**THE HILLS SHIRE COUNCIL**  
3 Columbia Court, Norwest NSW 2153  
PO Box 7064, Norwest 2153  
ABN 25 034 494 656 | DX 9966 Norwest

21 August 2020

## **RESPONSE TO SUBMISSIONS – BELLA VISTA AND KELLYVILLE STATE SIGNIFICANT DEVELOPMENT APPLICATIONS**

Figure 4: EIS Ground Floor Setbacks (left) and as amended by the RtS (right)

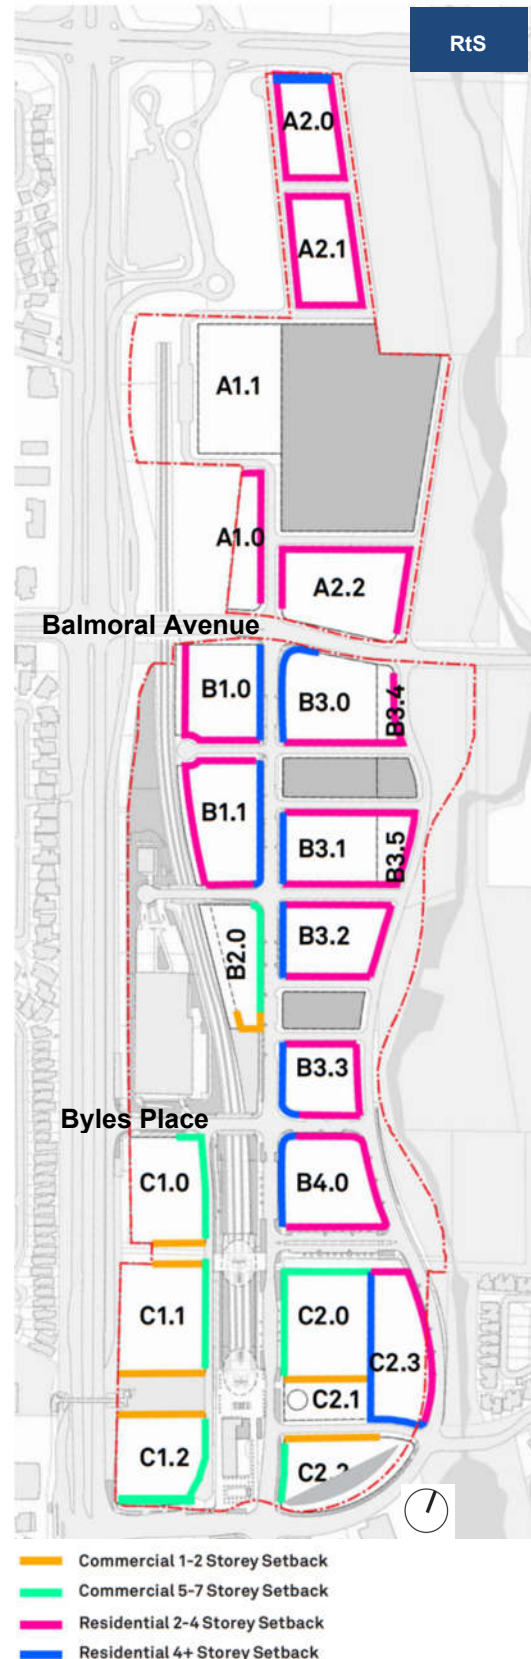
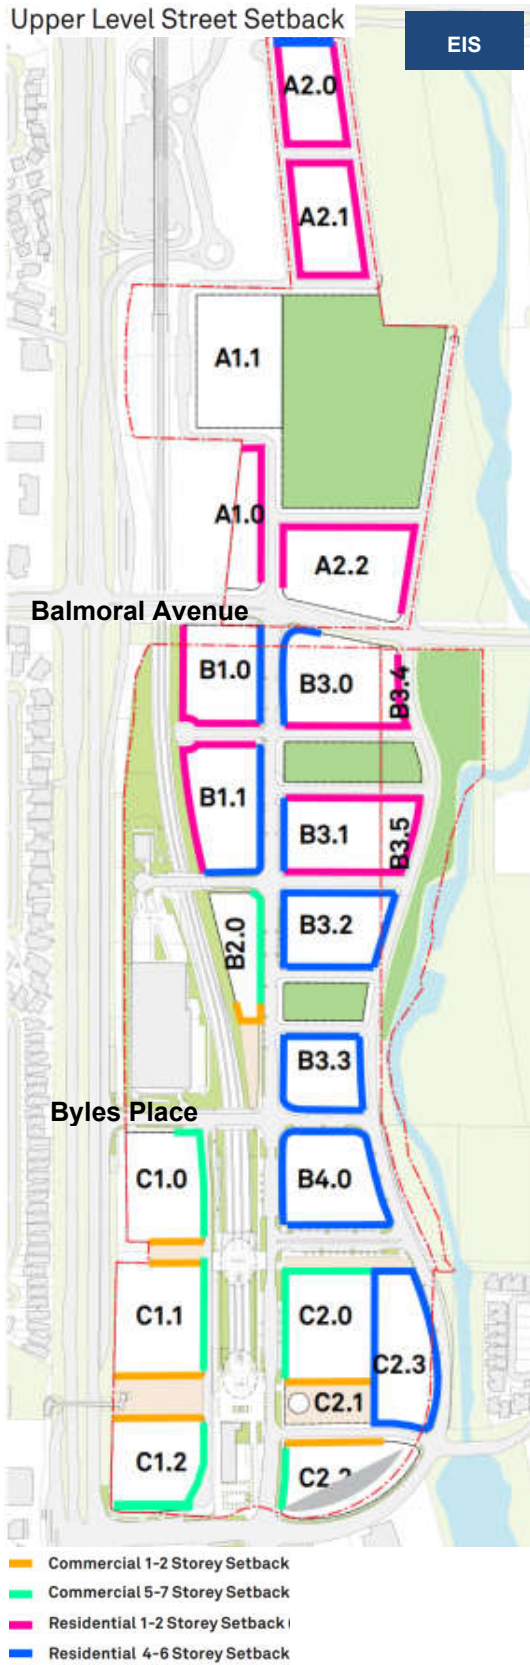
The comments raised within Council's submission are maintained. Applying standard building setbacks for high density residential development of 2m (Bella Vista Precinct) and 3m (Kellyville Precinct) is not supported. In order to facilitate adequate landscaping and building separation within high density residential areas outside of a town centre core, buildings should be setback around 5m from the property boundary. As mentioned within Council's submission, consideration may be given to reduced setbacks where a terrace edge is provided.

Figure 12: Development Blocks Identified for Terrace Typologies

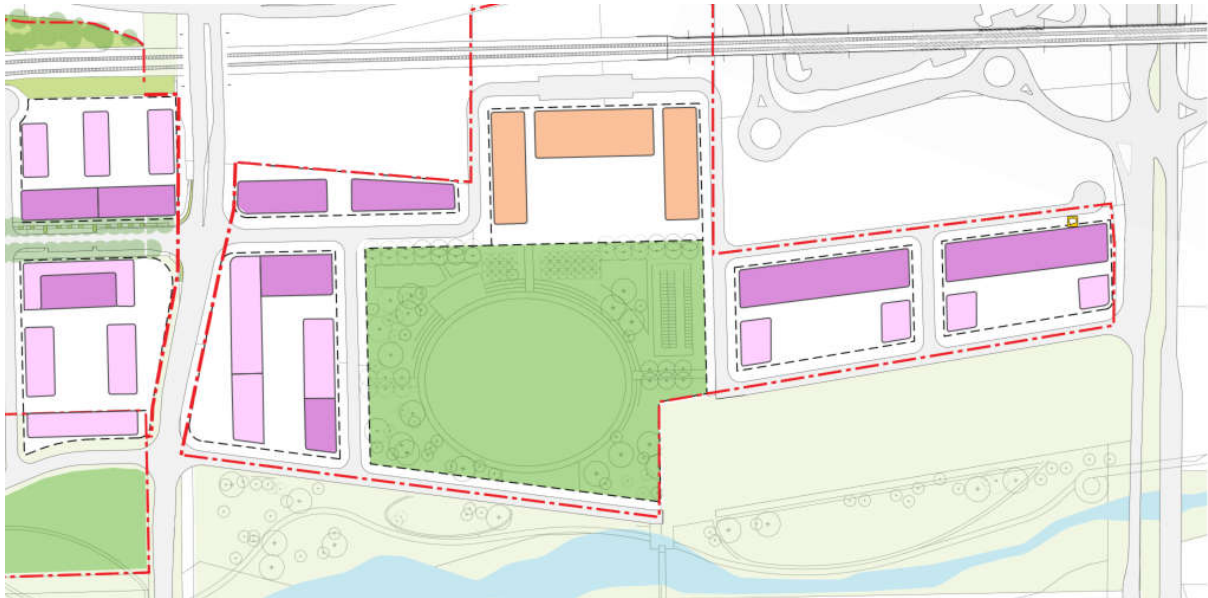
Council's submission identified '*whilst the proposed GFA ranges will go some way to securing the provision of medium density forms such as terraces, it is considered this could be further secured by specifying a minimum percentage of terrace style housing for certain sites*'. In response to this submission for the Bella Vista Precinct a 5% terrace requirement has been applied to sites A2.0, A2.1 and A2.2.

This would equate to around 40 dwellings based on the maximum dwelling projections. With respect to the Kellyville Precinct, no minimum terrace requirement has been identified. It is considered that given the corridor is being master planned, with most of the corridor being developable Government land, there is significant capacity for Landcom to require a mix of housing typologies and to specify a minimum provision of medium density/ terrace dwellings.
